## **FIRE RISK MANAGEMENT, INC.**

# **Memo Report**

**From:** W. Mark Cummings, P.E.  
**To:** Mr. Bill Hopkins; Archetype Architects  
**Subject:** **Fire Protection & Life Safety Review of the Proposed Maine Wharf Museum**

This initial review focused primarily on the proposed renovations for the 2<sup>nd</sup> and 3<sup>rd</sup> floor levels and their potential use as a museum; and specifically evaluating the available means of egress from these upper floors. The primary codes being referenced are NFPA 101 and the IBC/MUBEC. This review was based on the drawings provided by Archetype Architects; dated 05/13/2015.

5 | STAIR SECTION B
SCALE: 1/4"=1'-0"

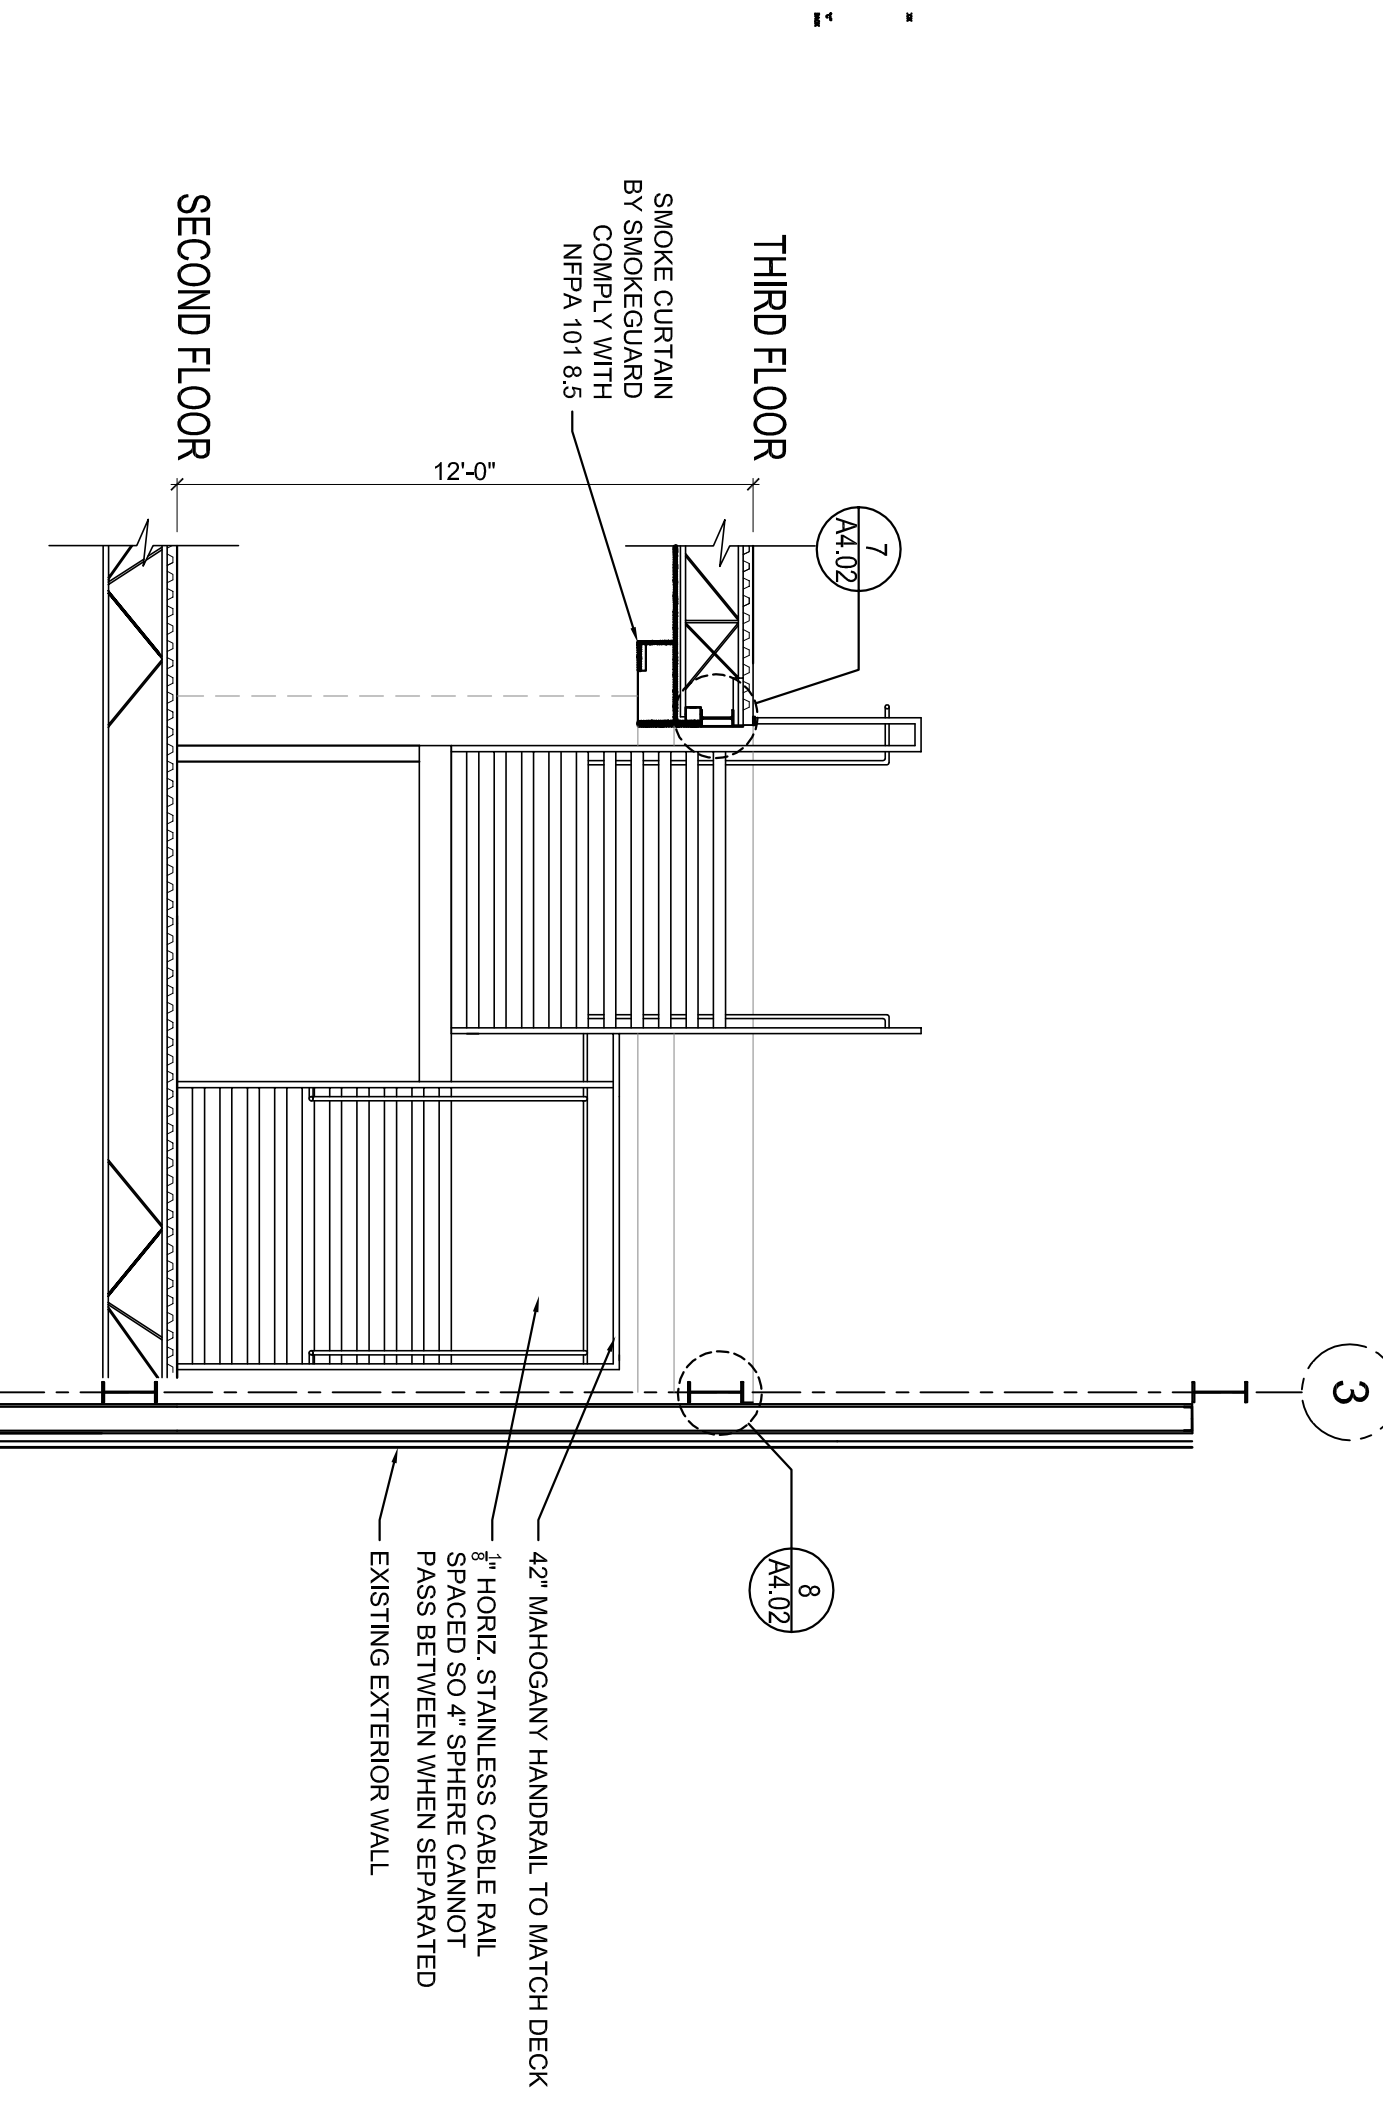
Specifically, the common path of travel distance from the southeast end of each floor will exceed that which is allowed by NFPA 101. Although a new stair is to be included near the southeast corner of the building, this stair only connects the 2<sup>nd</sup> and 3<sup>rd</sup> floor levels and is currently designed as being “open;” effectively meeting the NFPA definition of a “convenience opening” (stair), per section 8.6.8 of NFPA 101. Such openings/stairs are not permitted to be used as part of any required means of egress.

In addition to meeting the Tenant’s requirements regarding the “flow” of people through the museum’s exhibits, it is understood that there is a desire to keep this stairway open to also allow for additional natural lighting within the museum space. However, if this stairway is to be considered as an option to alleviate the lack of compliance for common path of travel, it will need to be isolated from the rest of the building by barriers having a fire resistance rating of at least one hour, or be protected in a manner that has been deemed as providing equivalent protection through the implementation of a performance-based approach and that has been accepted by the Authority(ies) Having Jurisdiction (AHJs); which likely includes the State of Maine’s Fire Marshals Office and the City of Portland’s Fire Prevention Bureau.

A possible option that could be explored for protecting the stairway in the southeast portion of the building, while continuing to meet the Tenant’s requirements/expectations, would be to enclose the stair using walls and doors that incorporate glass panels. The glass could then be protected by modifying the existing sprinkler system, at each level, to include additional sprinklers located around the periphery of the stair enclosure, designed such that all portions of any exposed glass would be subject to direct water application. This is a method that is routinely used to protect glass walls/panels that form barriers of atriums. If it is also desired that the doors that provide access to this stairway remain open at all times other than in an emergency, magnetic hold-open devices could be installed that are operated by the fire detection/alarm system; via actuation of adjacent smoke detectors as outlined in NFPA 72.

Based on the initial review of the plans provided for the proposed renovations to the 2<sup>nd</sup> and 3<sup>rd</sup> floors of the Maine Wharf building, it will be necessary to take steps to alleviate the excessive length of the common path of travel distance from the southeast end of the building. Without making major structural changes to the building itself, beyond that which is already planned, the most viable option to correct this code deficiency appears to be providing separation for the stairway connecting the 2<sup>nd</sup> and 3<sup>rd</sup> floor levels in this area of the building. Based on discussions regarding the Tenant’s requirements for the museum, it is recommended that consideration be given to separating this stairway from the remainder of the building, using an alternative approach that is designed to provide an equivalent level of protection to that which would be afforded if “standard” fire rated assemblies were used. It is believed this can be achieved through the use of glass, or partial glass, walls and doors that are specifically protected using the installed fire sprinkler system. Equally, automatic closing doors controlled by the fire alarm system could also be used to allow the uninterrupted flow along these stairs during normal operations. However, any such approach will need to be approved by the AHJ(s); and such approval should be obtained prior to moving forward with any efforts along these lines to ensure they are, in fact, willing to consider a performance-based alternative.
